Online Comment

Application H04-0823-17
Location Ing Drove Donington
Proposal Installation of high voltage Direct Current cables for the Viking Link interconnector project between proposed landfall at Boygriff in East Lindsey to a proposed converter station at North Ing Drove; installation of Alternative Current cables from the converter station to the existing Bicker Fen 400 kV Substation; as well as permanent access road to converter station, temporary facilities required during construction such as compounds and works areas

Name Mrs D Fairweather
Address Clerk to Donington Parish Council 85 Northorpe Road Donington PE11 4XX

Date Submitted 14-10-17
For/Against Objections

Permanent Access Road Junction Design

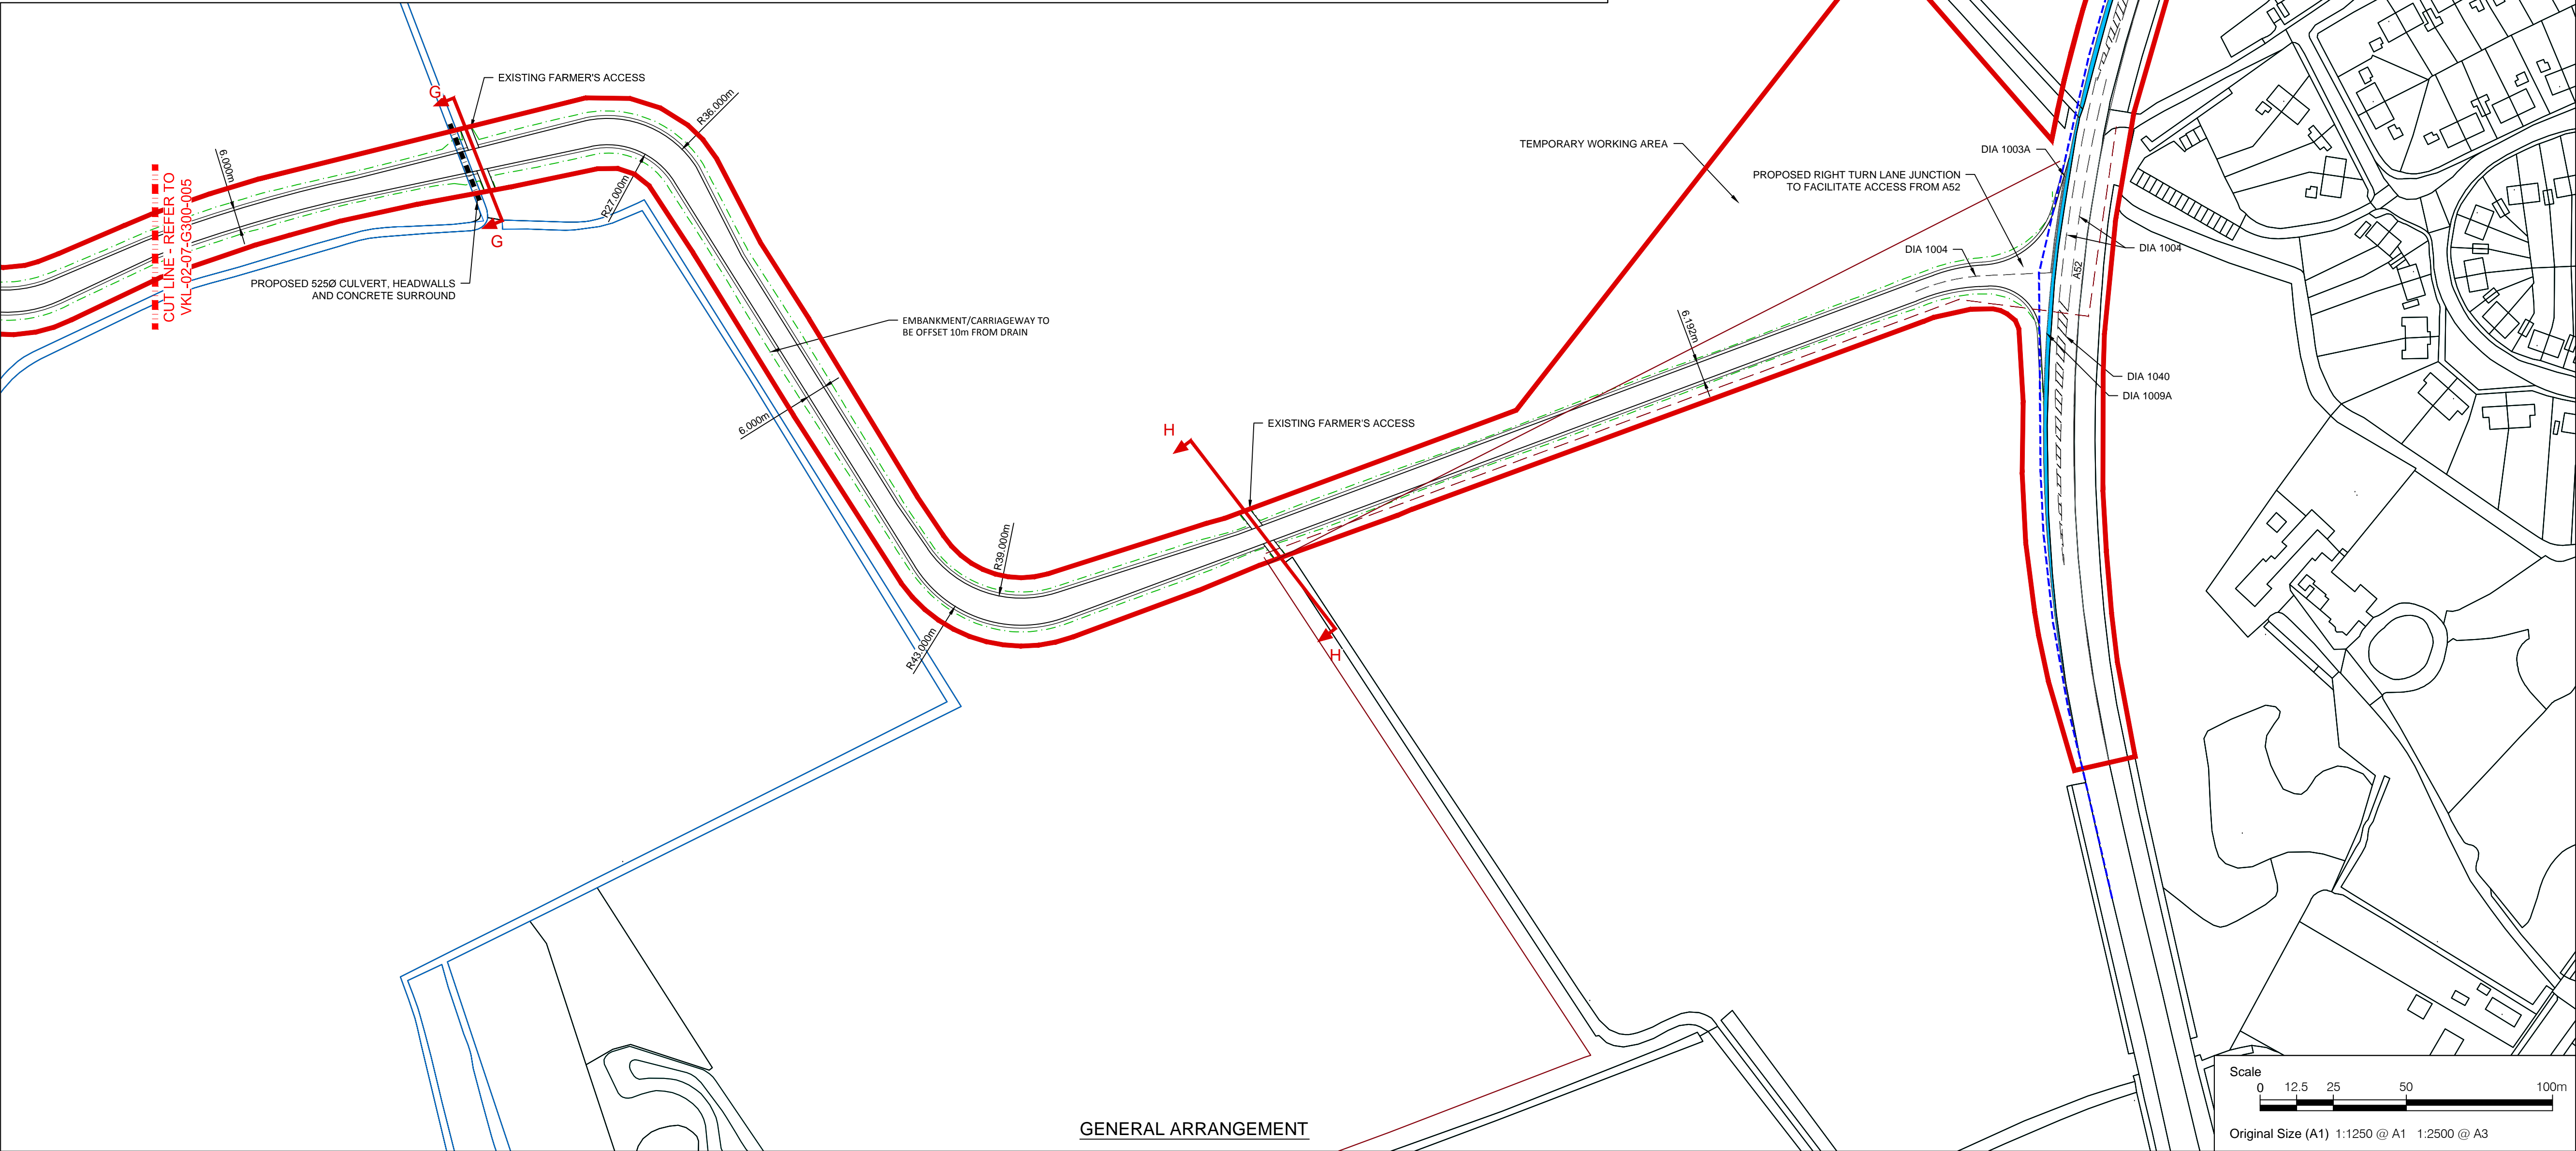
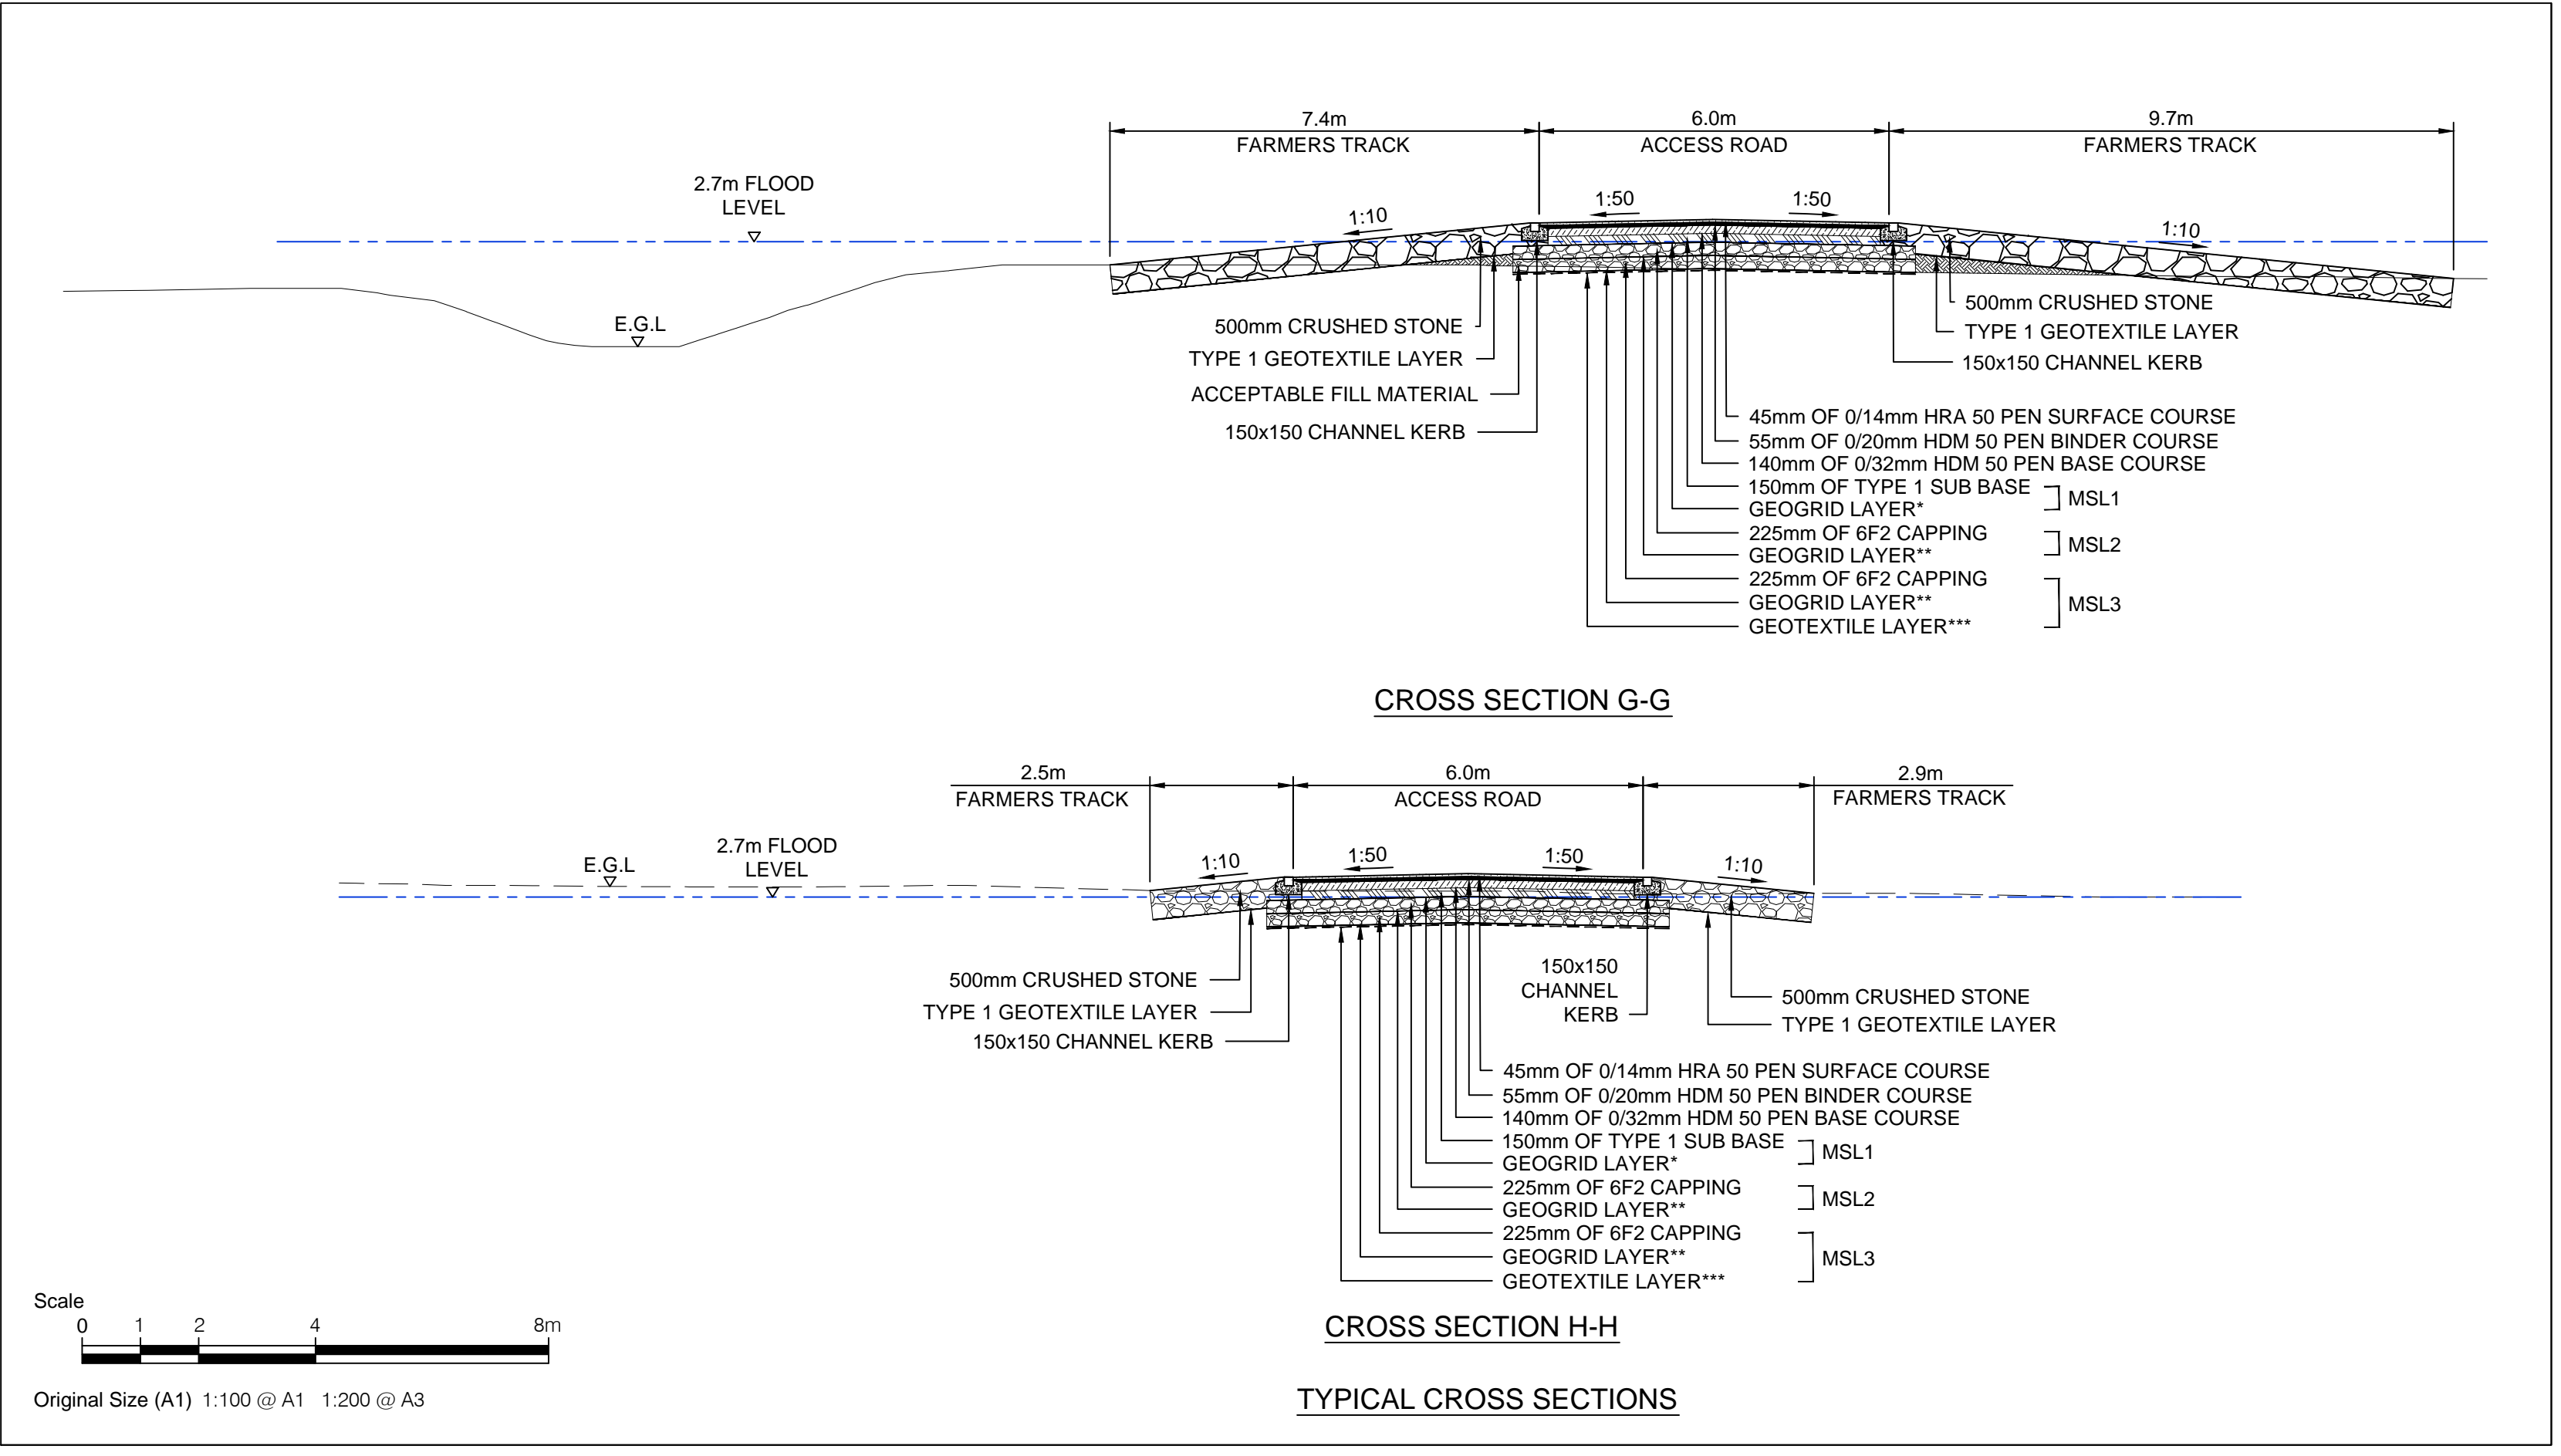
It is felt that the fencing to the A standard access road should not be solid but more open to allow wildlife to still have their freedom in the Northorpe. It would also be preferred for it to be a temporary fence, to be removed after construction. Farmers will be very inconvenienced during the construction without this continuing permanently.
